OAKLANDS FARM SOLAR PARK

The Applicant's Reponse to Local Impact Reports

August 2024

Document Ref: EN010122/D3/11.4

Figure 4.10a: Illustrative Access Tracks - Permanent and Temporary (North)

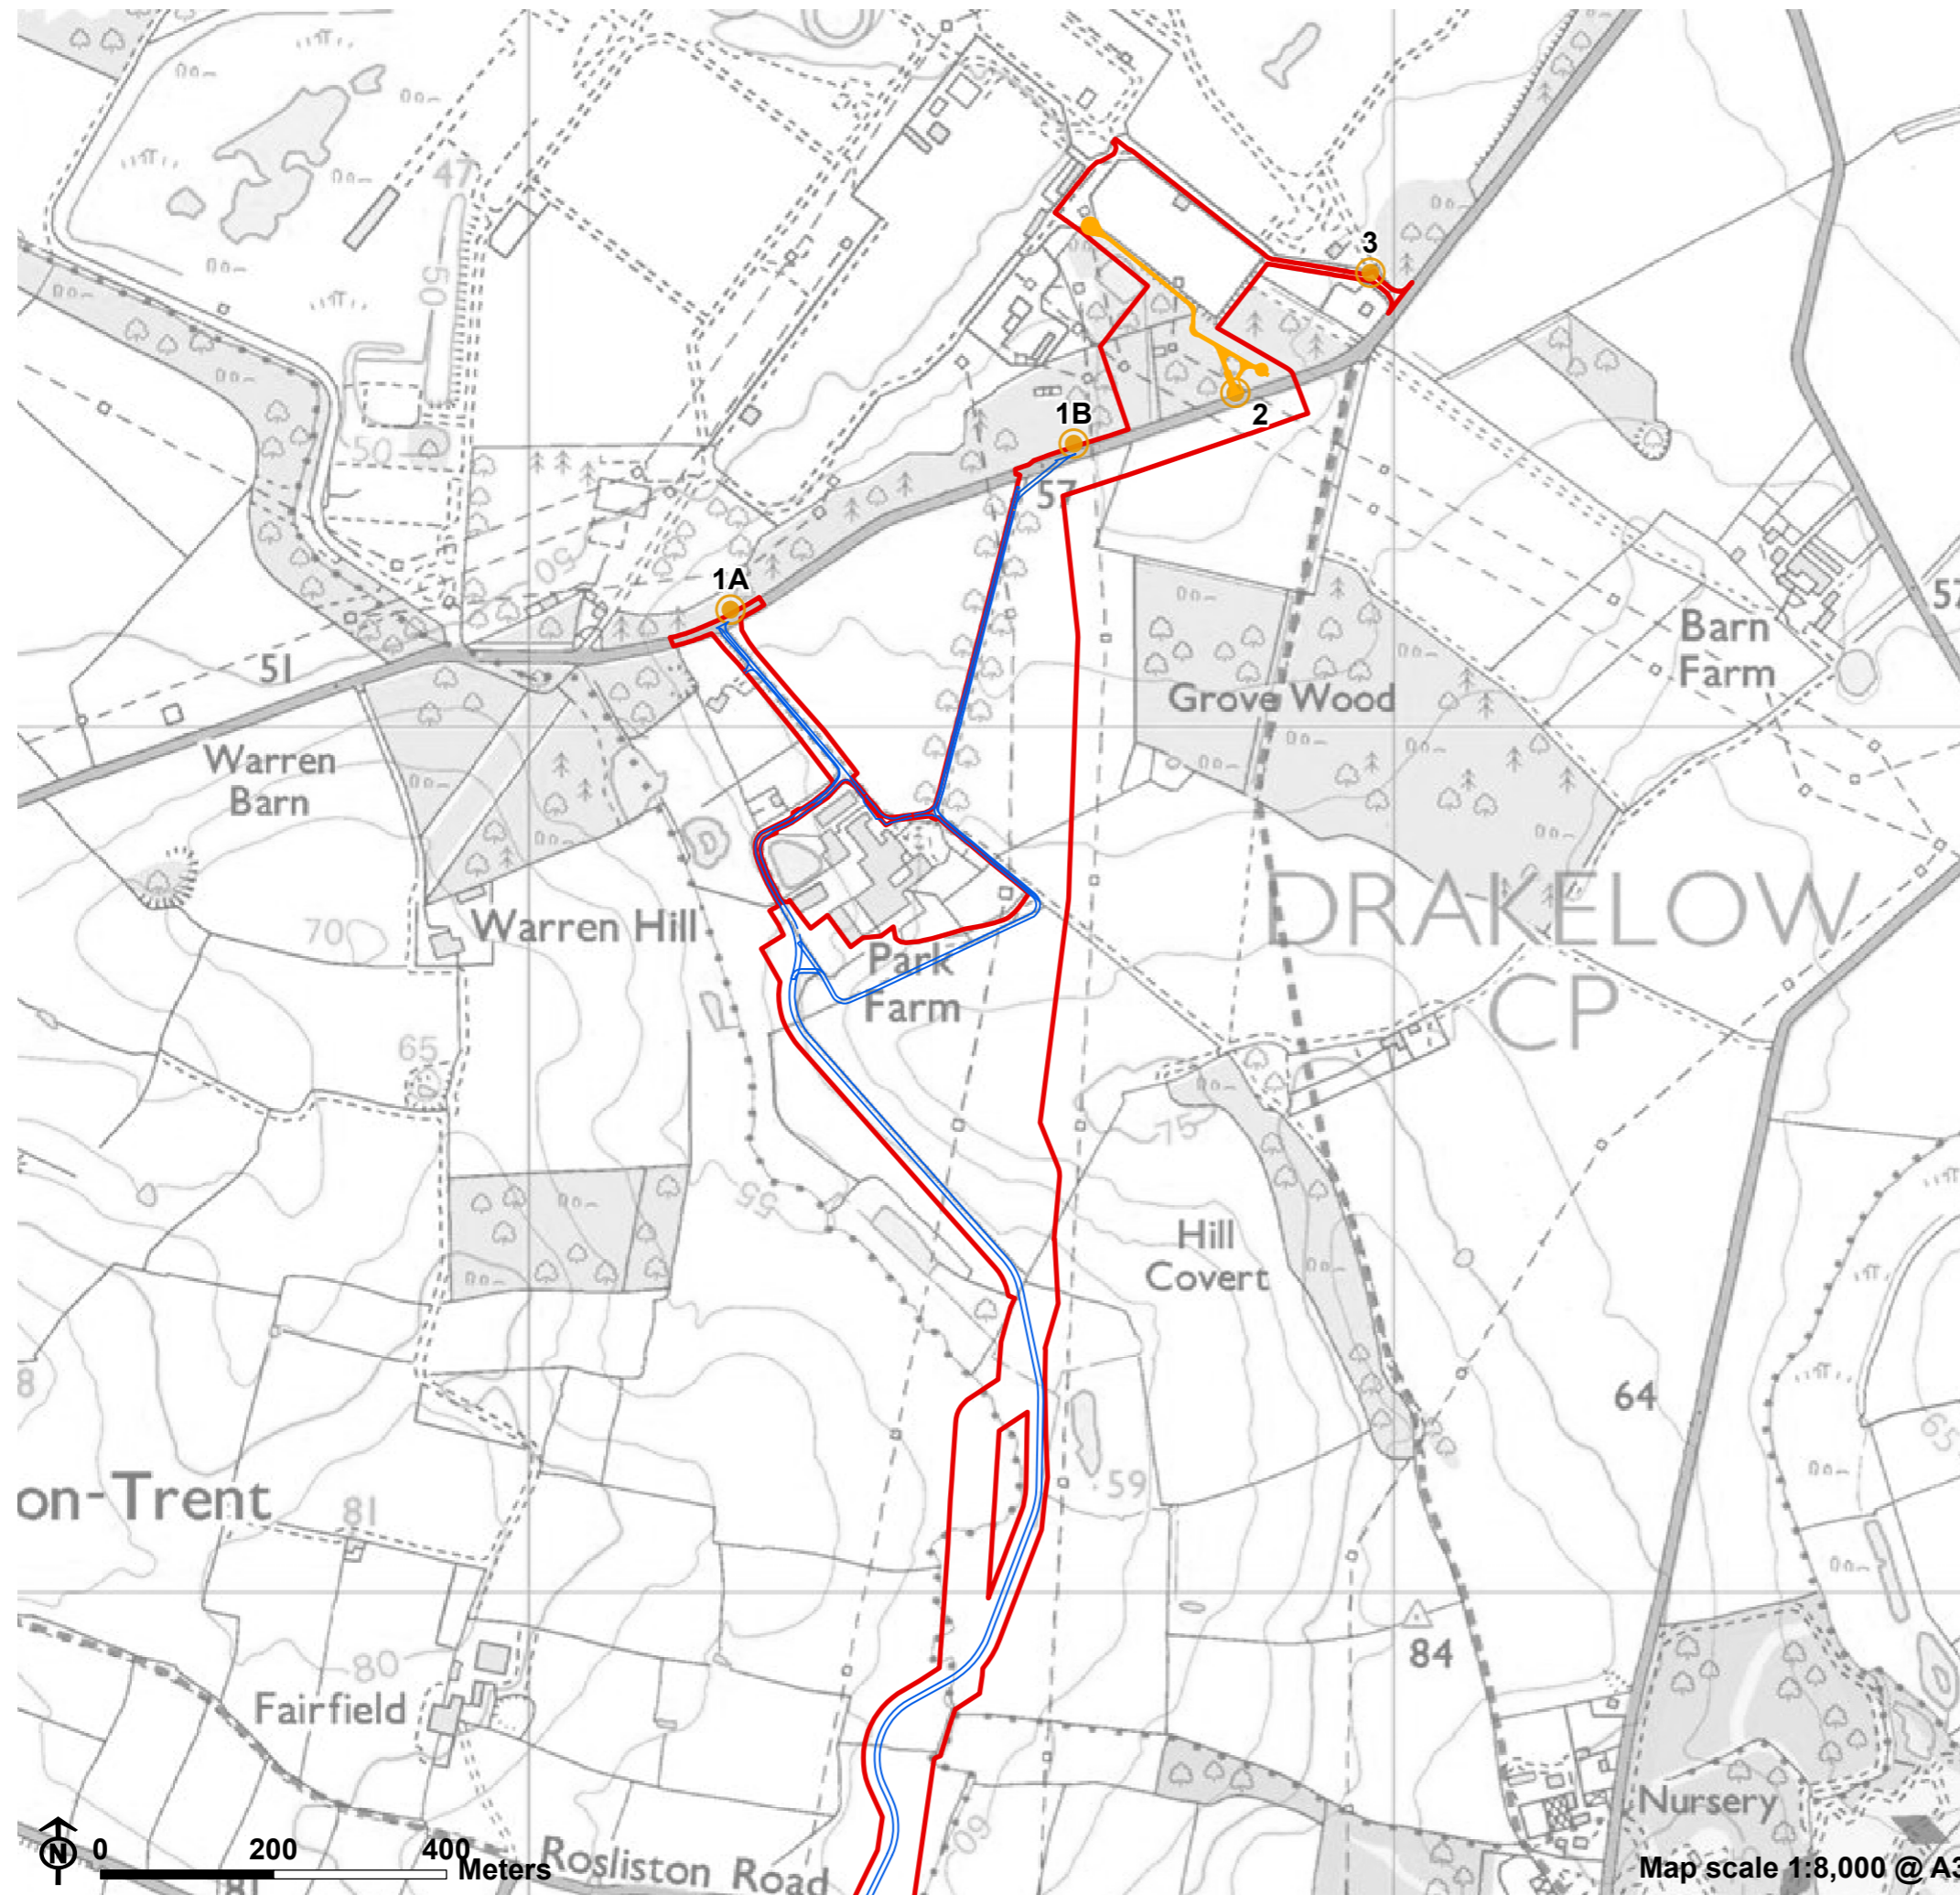
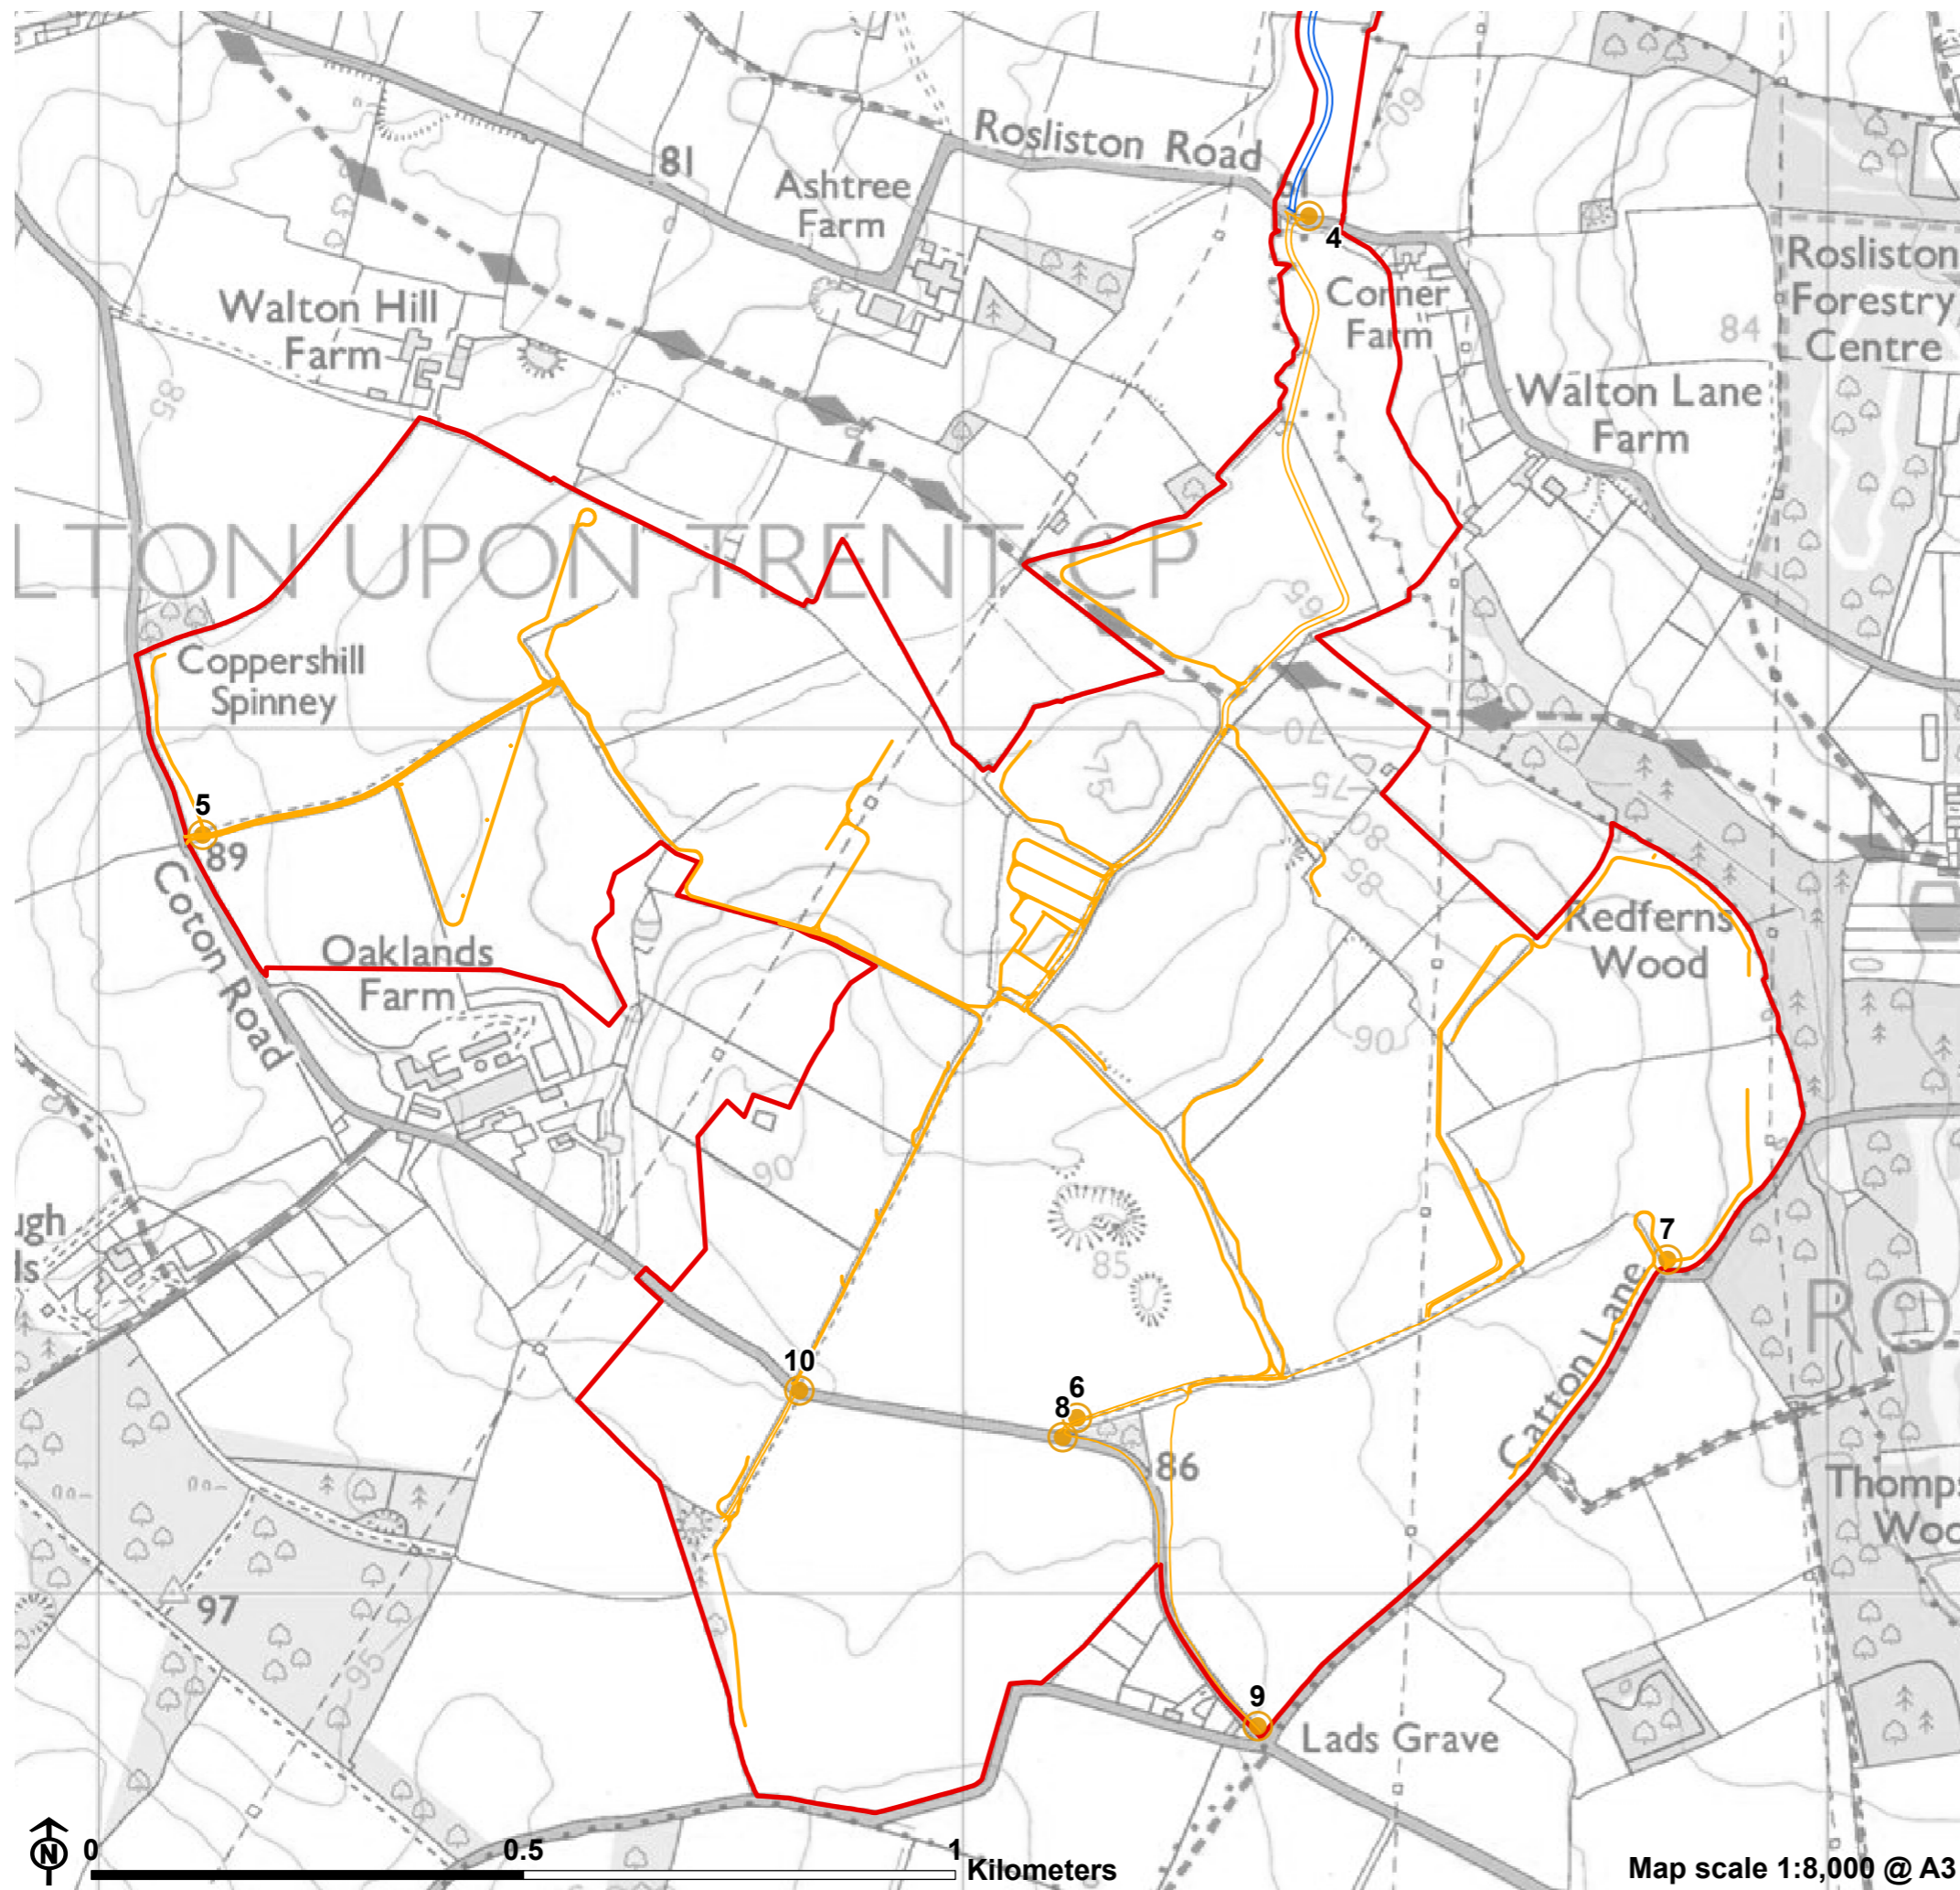
-
- 5.26 Within the site itself, a network of internal haul roads will be established that range from 3.5-6m to provide construction access, which will be retained to a 3.5m width to be utilised during the operation of the development. The councils will need to establish that there are safe and satisfactory means of access to each of the individual compounds comprising the wider site.

- As set out in Figures 4.10a and 4.10b **[AS-015]** only accesses 2, 3, 4 and 10 will be retained for operational use, with access point 10 providing the main operational access.
-
